Department of Planning's Response to Agency Submissions		
City of Sydney	Concerns about bulk and scale, including use of pre-cast white panels. Wider than City's requirement for residential towers (40m). Mass should be broken up.	The revised design provided in the PPR is considered to result in an acceptable appearance of bulk and scale. A revised design was carried out in consultation with the Council. The Council advised the Department the revised design, materials and colours are satisfactory.
	Podium should match height of ABC indented podium.	The podium is already substantially built, where it is being extended it will match the existing PJB podium height. This is similar in scale to the ABC building, and therefore resultant design is considered to be satisfactory.
	Treatment of façade should be opened to increase passive surveillance of the UPN.	The proposal will introduce level access from the UPN, to an entry foyer for the student housing and space for a café. This is considered to be a significant improvement for interaction and surveillance of the UPN.

### Department of Planning's Response to Public Submissions

Level 2 - Podium Plan

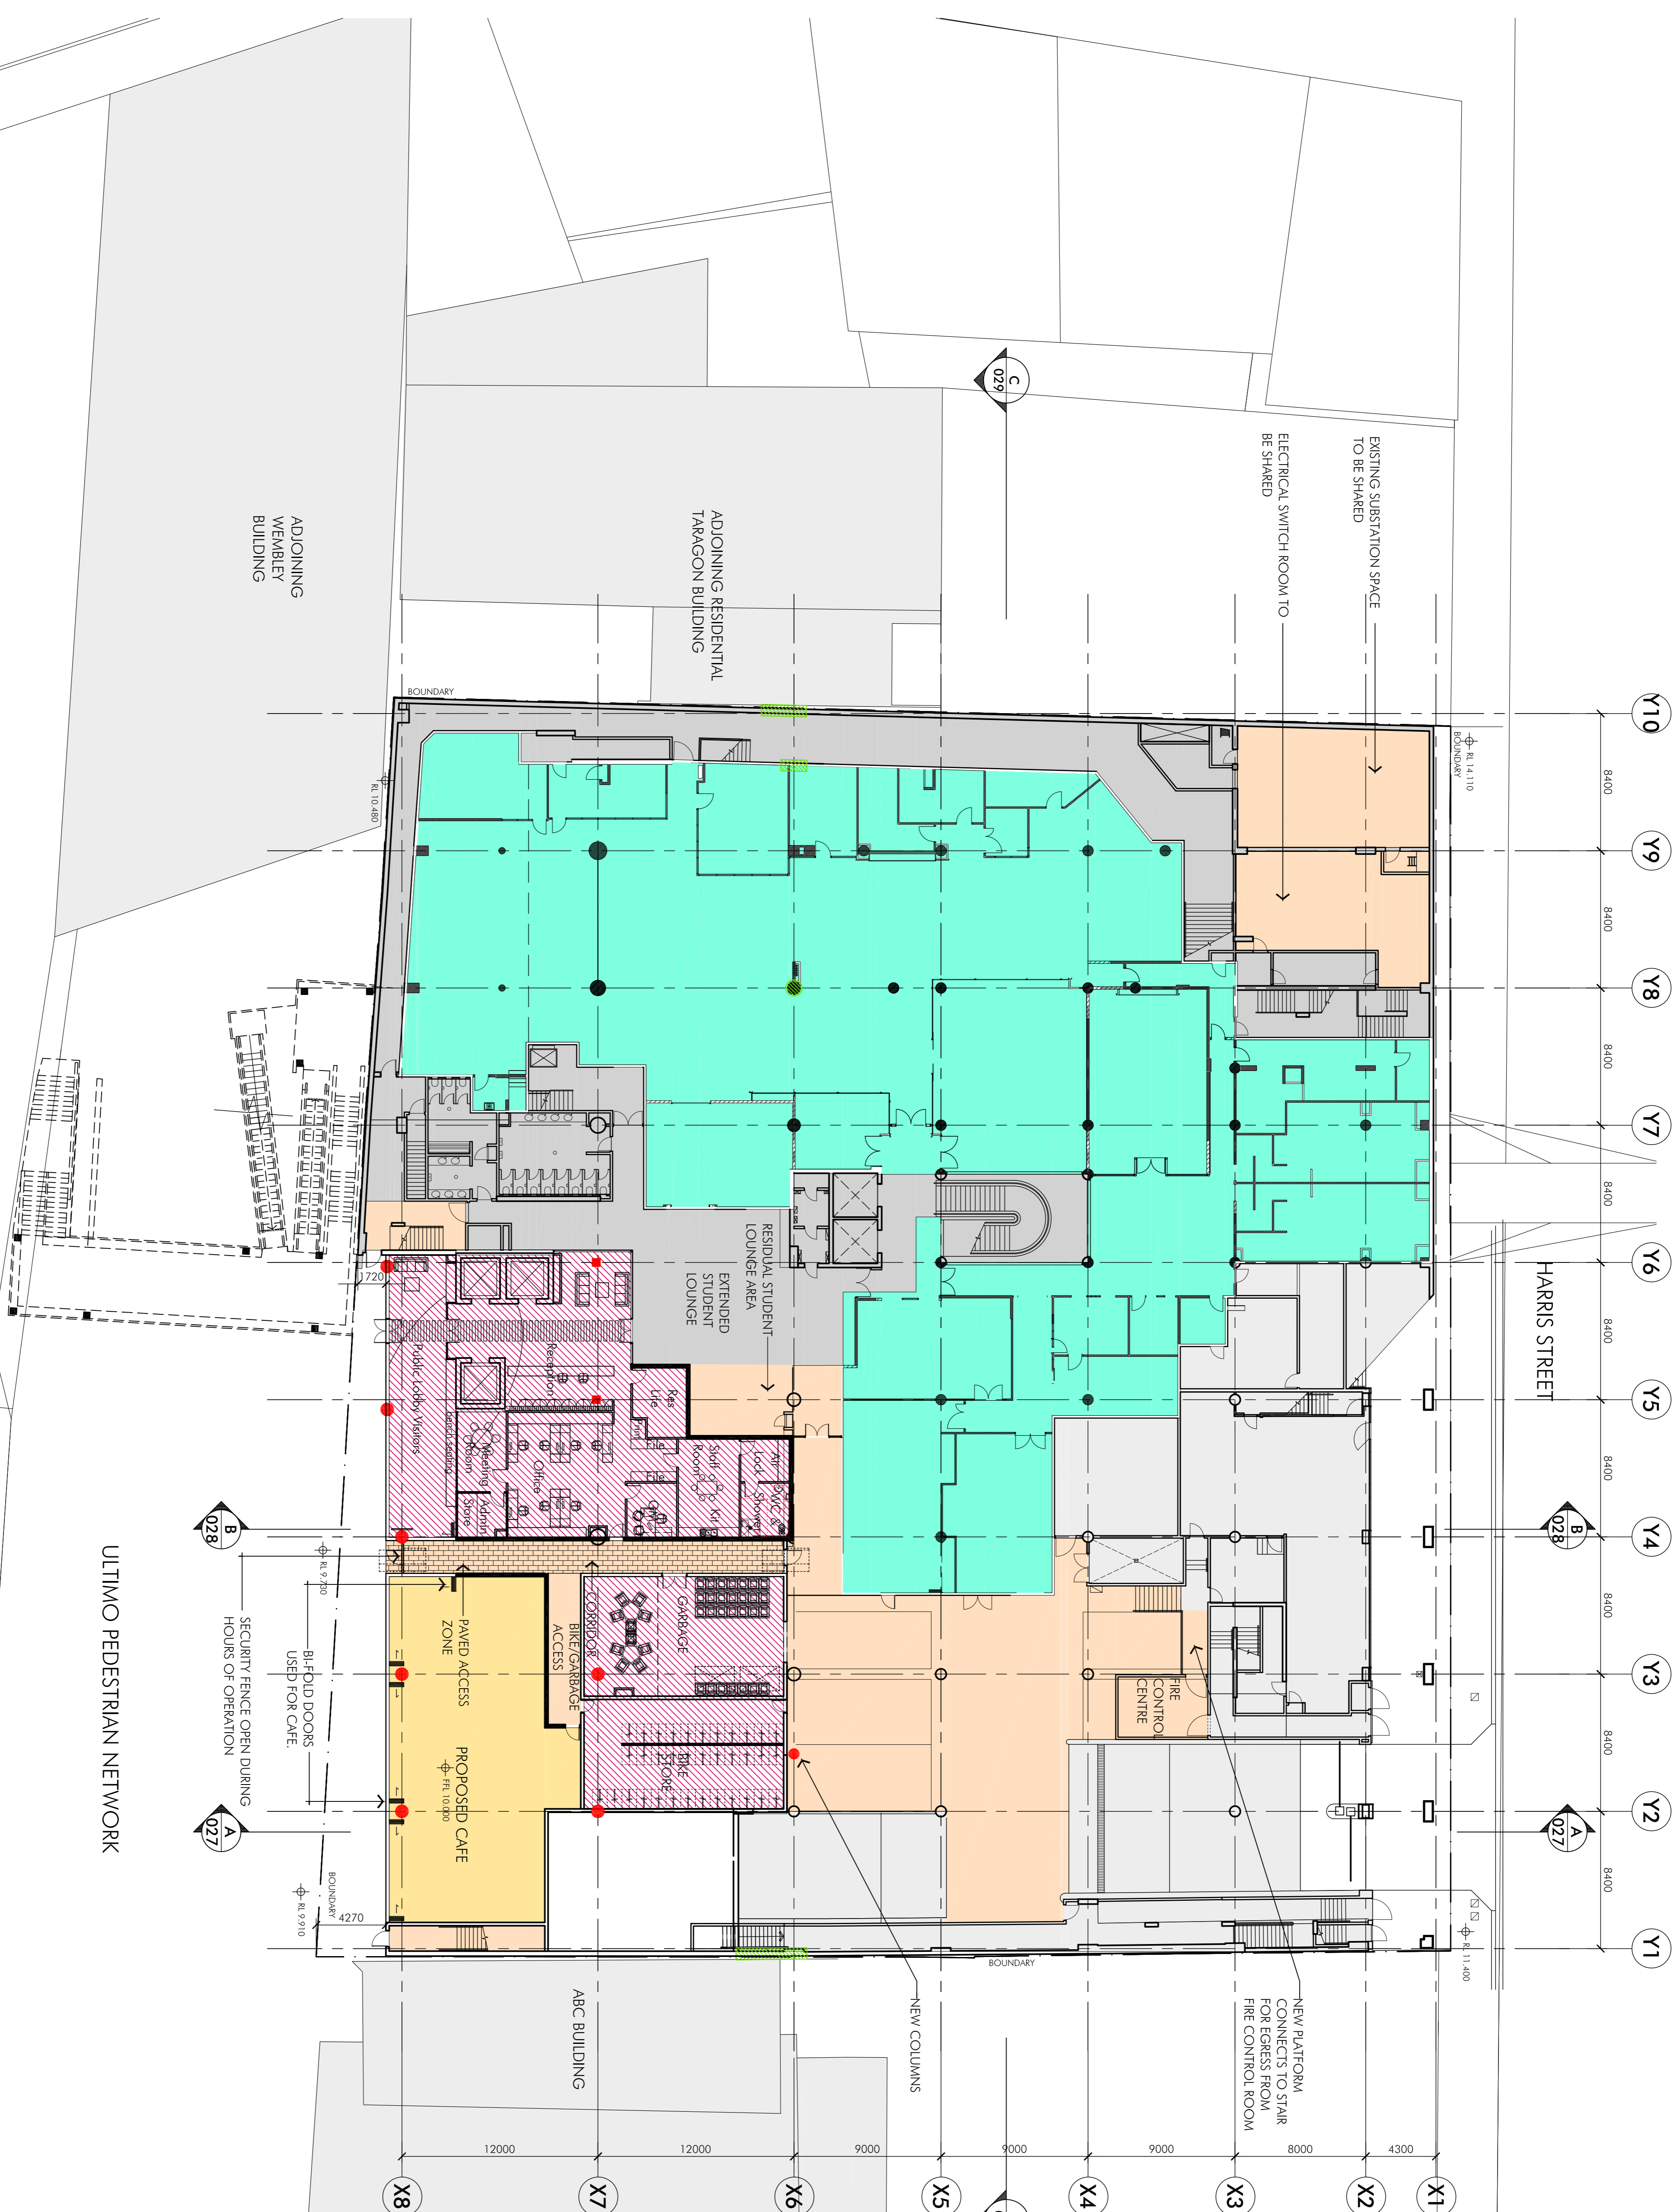
Overhead pedestrian bridge should be removed.	The UPN bridge and stair/escalator provides a publicly accessible path from the Devonshire St Tunnel to the main campus. The Department considers that the issue will be best addressed as part of the UTS Broadway Concept Plan which covers public domain improvements and pedestrian paths of travel.
	Student units do not comply with SEPP 65 and have a poor standard of internal amenity and layout.	Accommodation is similar to a university college, and temporary. Other services and communal areas to be provided increase the amenity for residents. The outcome is considered to be satisfactory.
	Some facing windows less than 2m away.	This issue has been addressed in the PPR and assessment report. Screening devices (that still provide solar access to meet the BCA) have been proposed and are considered to be satisfactory
	Should provide a mix of unit styles and sizes, with each floor containing communal areas.	A mix of studio units and shared units are provided. Large communal areas on Levels 8 and the rooftop are considered to be satisfactory. Other student facilities are also available on other parts of the UTS campus.
